PROJECT NAME: Drainage Improvements

PROPOSED DEVELOPMENT ADDRESS:
60 Oaklawn Road, Peaks, Island, Maine

PROJECT DESCRIPTION:
Replacement of failed drainage pipe system at residence.

From: Barbara Barhydt
Sent: Tuesday, October 06, 2015 10:10 AM
To: Silas Canavan
Subject: RE: 60 Oaklawn Road, Peaks Island

BOUNDARY SURVEY
60 OAKLAWN ROAD
PEAKS ISLAND, PORTLAND, CUMBERLAND COUNTY, MAINE

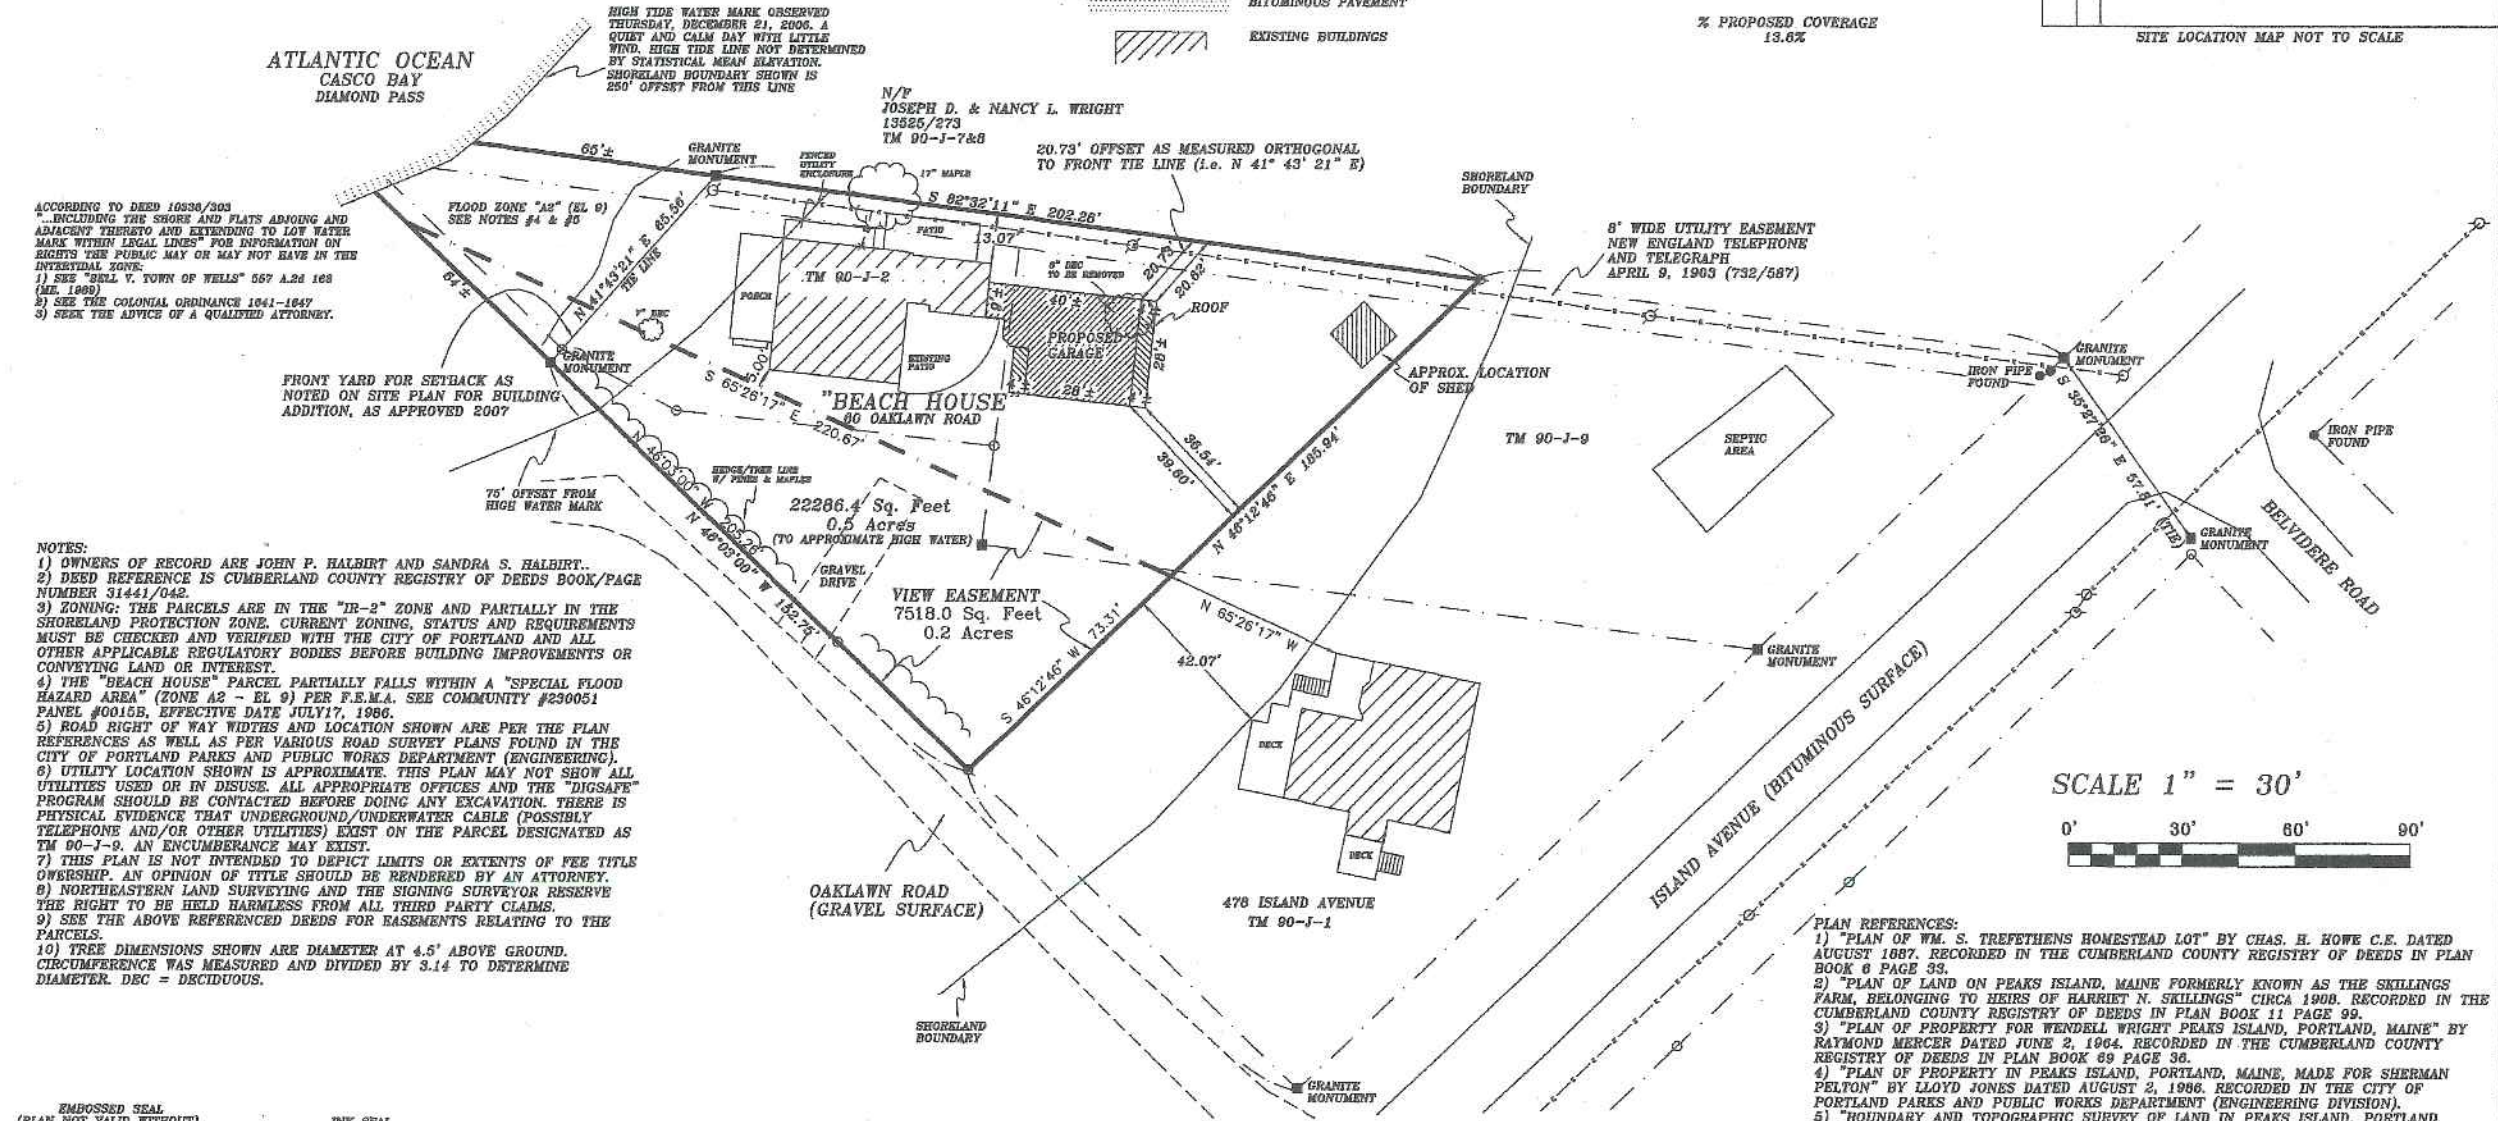
Survey looks good.

The odd thing was the setbacks parallel with the road and not perpendicular to the property line.

Otherwise, Lidar is fine for contours. Waiver OK for State Plane Coordinates also. I do not have a coordinate point in that area to provide to the surveyor.
